From: Jeff Smith <Jeffrey.Smith@endeavourenergy.com.au>
Sent: Thursday, 8 July 2021 9:30 AM
To: Grant Harlow
Subject: RE: S29/3/97-Mod-1 - Eastern Creek Karts, Departments design comments

Subject: S29/3/97-Mod-1 - Eastern Creek Karts, Departments design comments

Following on from our discussions on design requirements on 26th and 28th May 2021 for the above please see the following notes for design work :-

PMF Water Level (mAHD) and Depth (m) - Post Filling

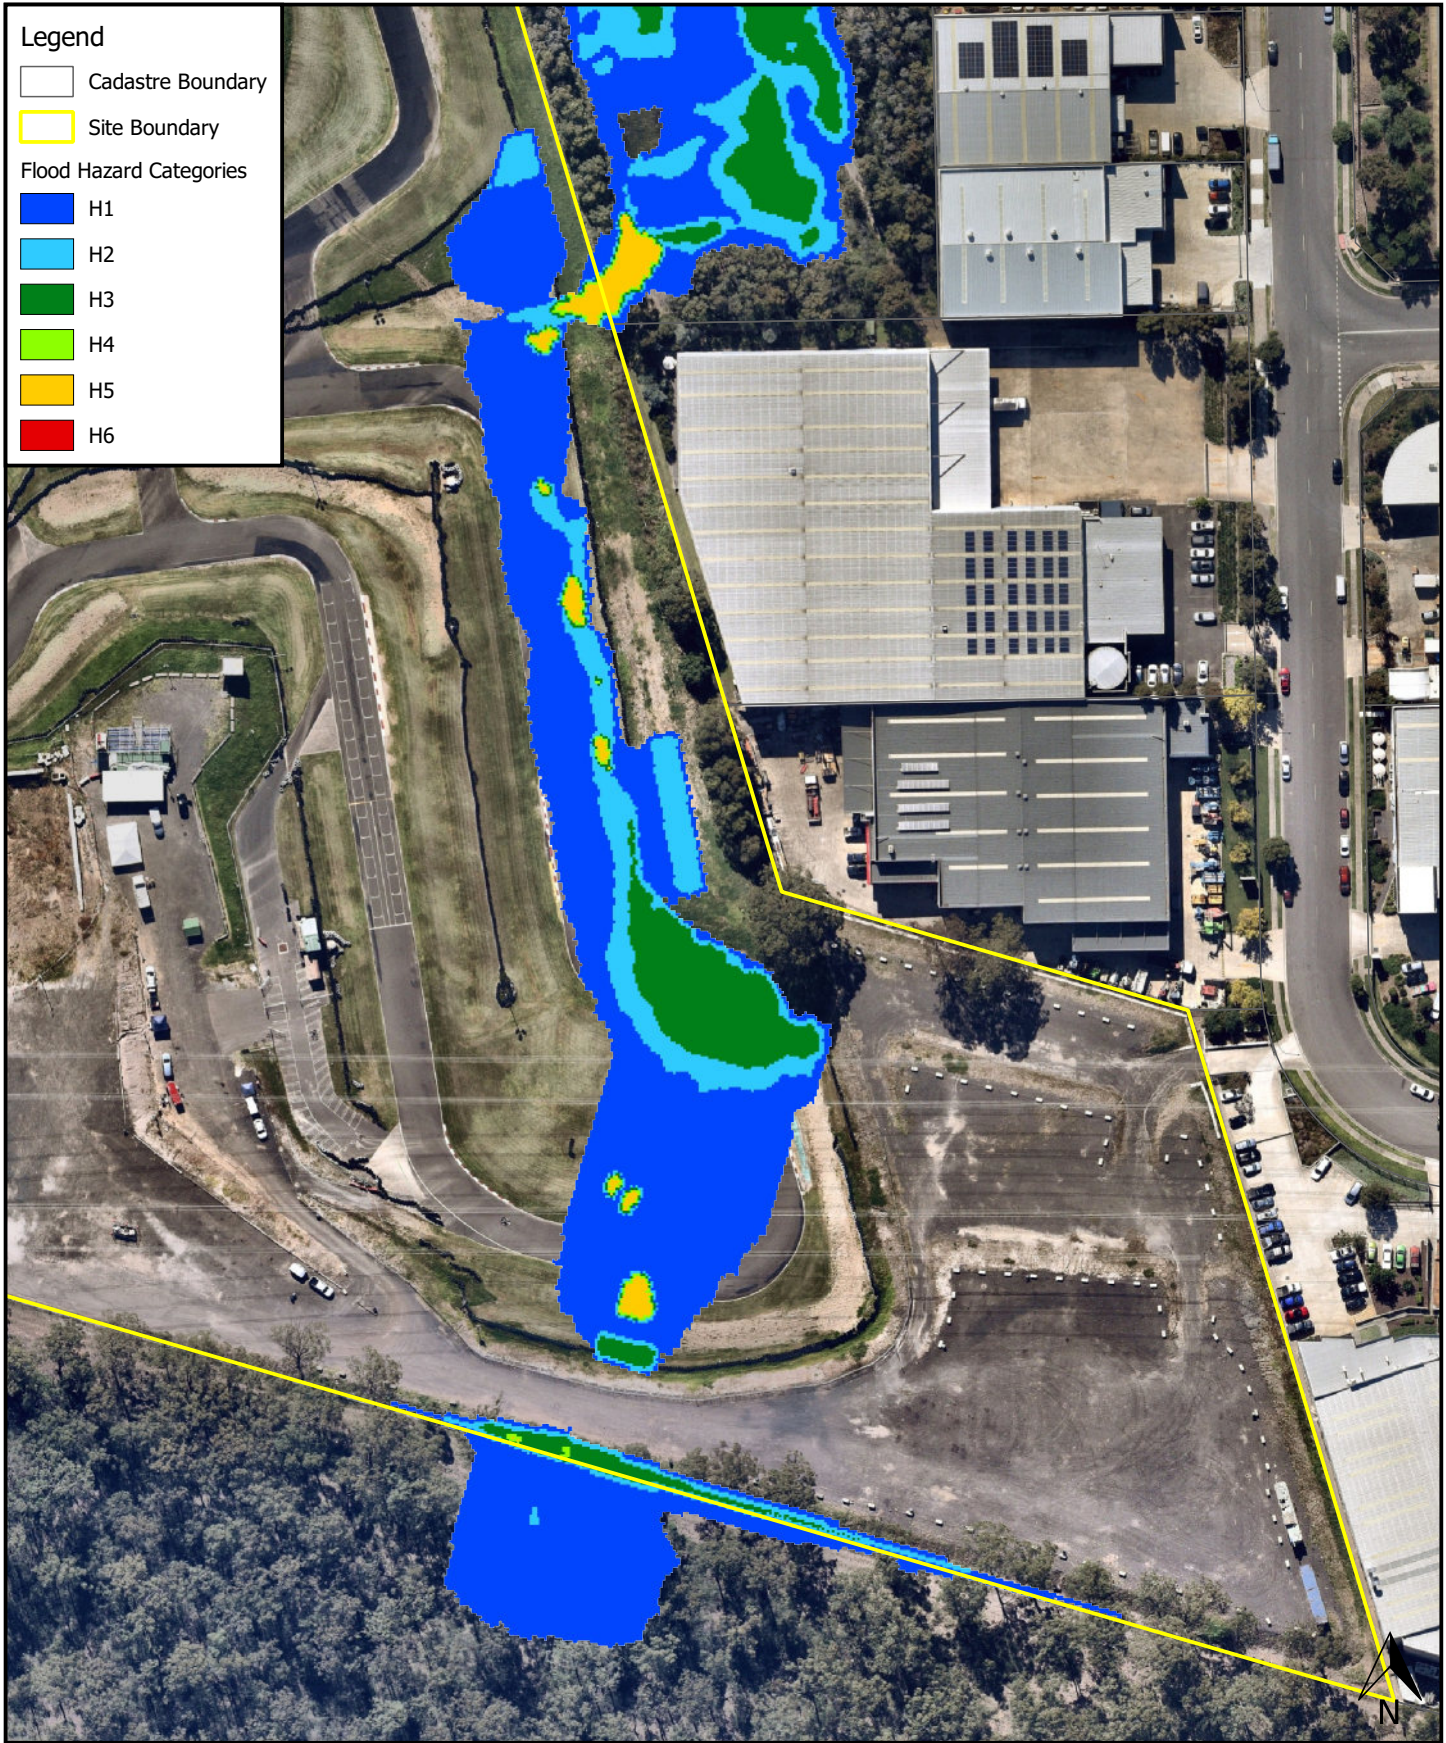
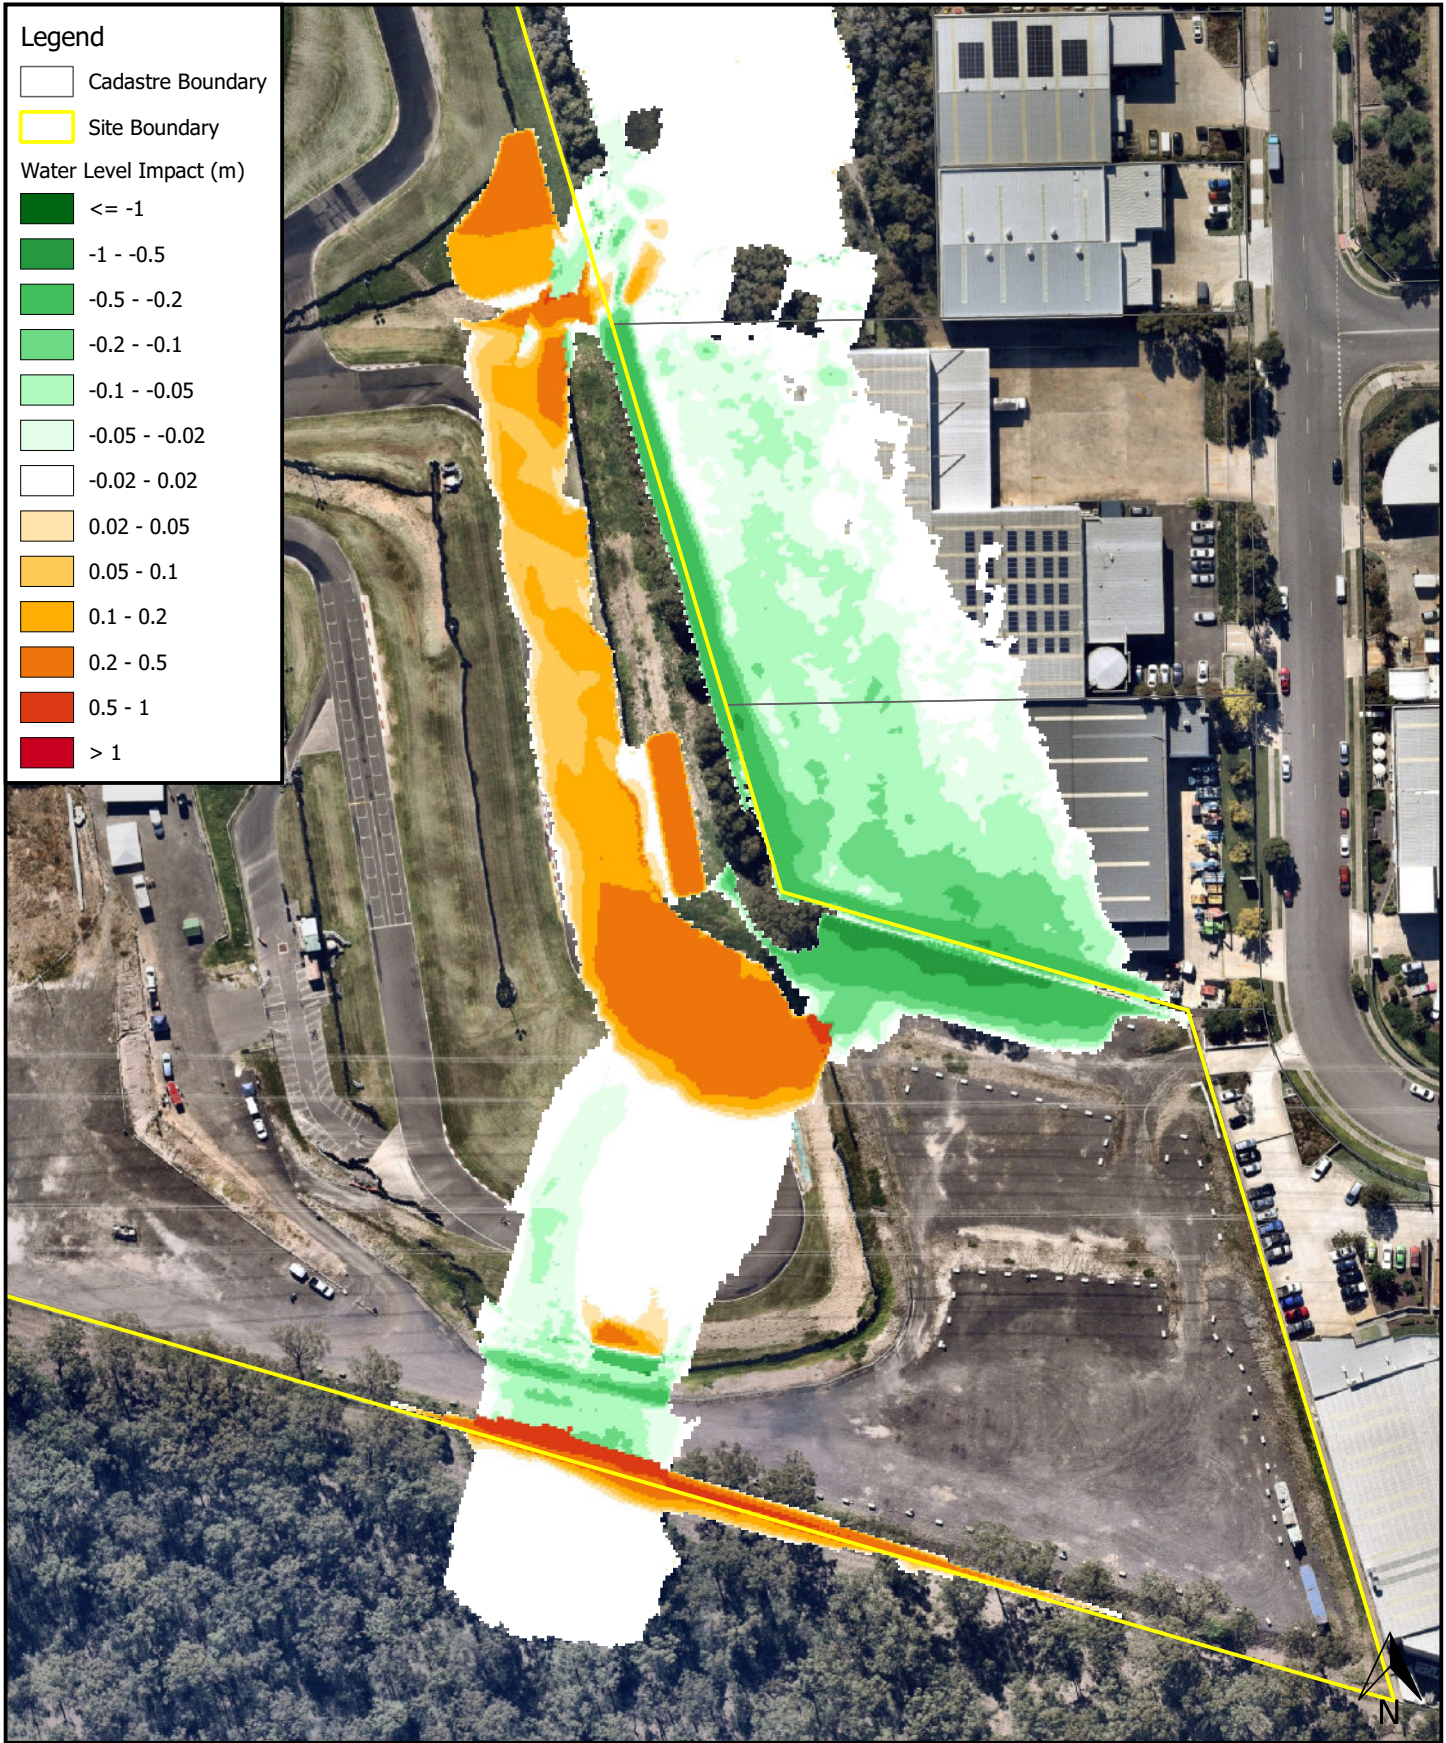
8. As example, the 100 yr ARI should be contained entirely within Karts land swales. A design check must be shown on TUFLOW output to ascertain impact on Prospect Reservoir land during the PMF, with preferably low hazard H1 results, to ensure constant and safe WaterNSW access on its perimeter road.
